16 December 2013

**Re: Sydney CBD and South East Light Rail proposal (SSI 6042)**

This letter is written on behalf of Grosvenor Place Management and the building owners of Grosvenor Place (Commonwealth Superannuation Corporation (**CSC**), Colonial First State Global Asset Management, Dexu Property Group and Investa). It considers the potential impacts of the Sydney CBD and South East Light Rail proposal (**CSELR**) on Grosvenor Place, which is located at 225 George Street, Sydney. Prepared in conjunction with Eastview Commercial Pty Ltd (**EVC**), Harry Seidler and Associates (**HSA**) and Traffix Traffic and Transport Consultants (**TTTC**)(Graham Pindar); the submission describes the existing improvements at Grosvenor Place, assesses the potential impacts of the CSELR and suggests measures that would ameliorate any negative impacts.

Figure 5.8 Indicative plan – Grosvenor Street stop

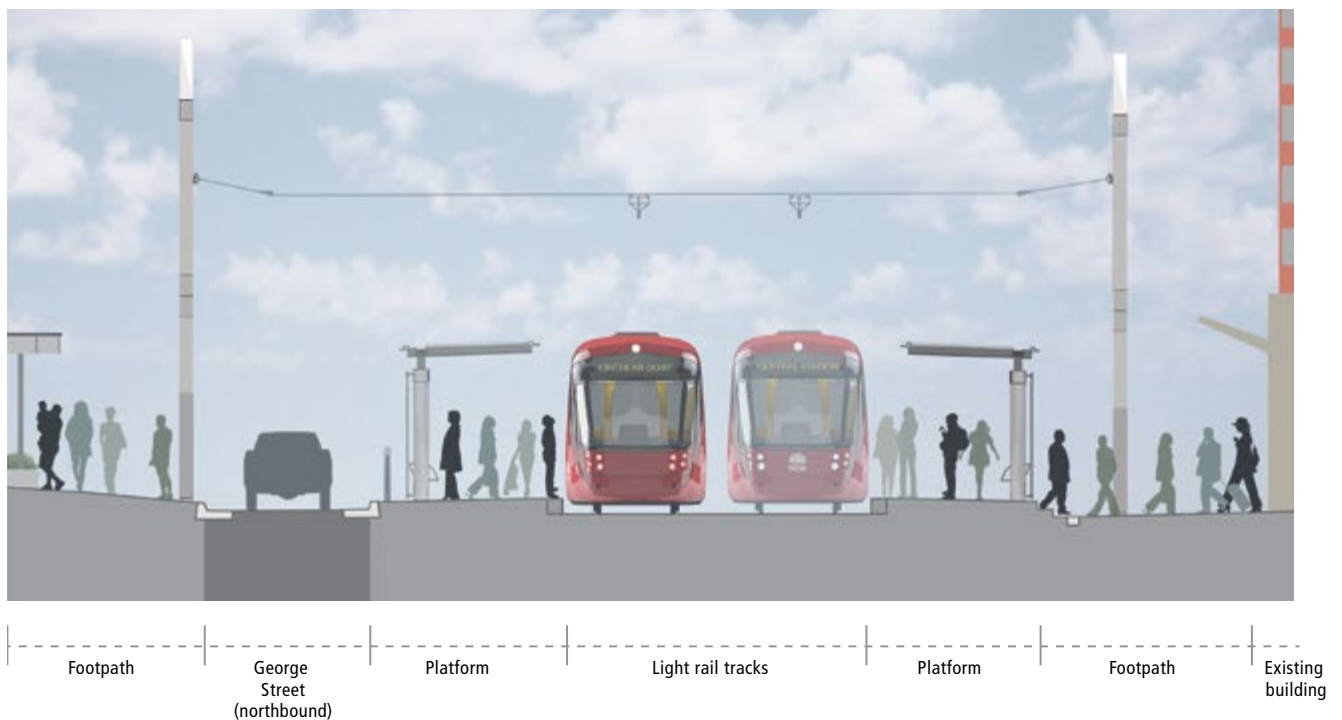
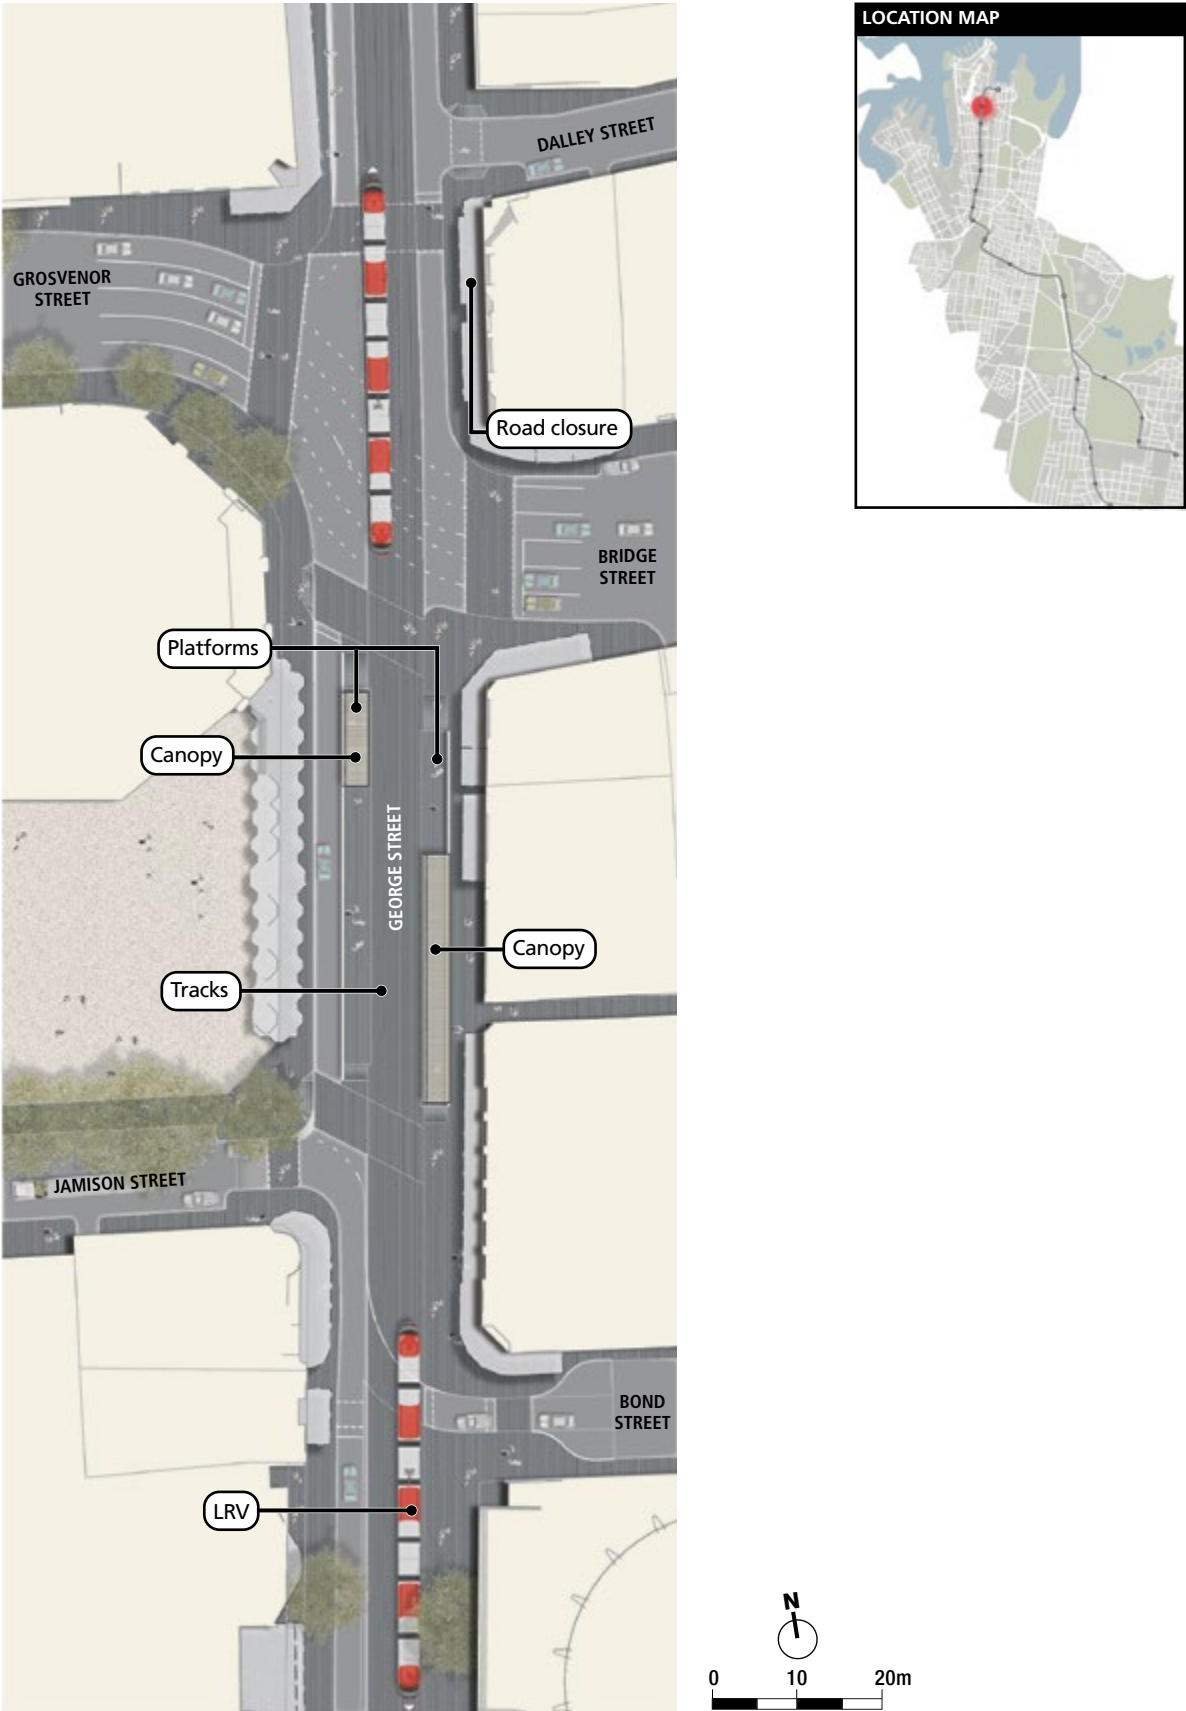
TTTC has considered the potential impacts of the CSELR on Grosvenor Place and notes that the introduction of pedestrianised areas within George Street and generally a single traffic lane traffic movement in each direction may affect the site. This traffic lane is intended only for local traffic movement and the importance of George Street as a route for through traffic is to be reduced. In particular, George Street between Hunter Street and Grosvenor Street will accommodate a single northbound lane but no southbound lane, due to the need to accommodate the Grosvenor Street light rail stop.
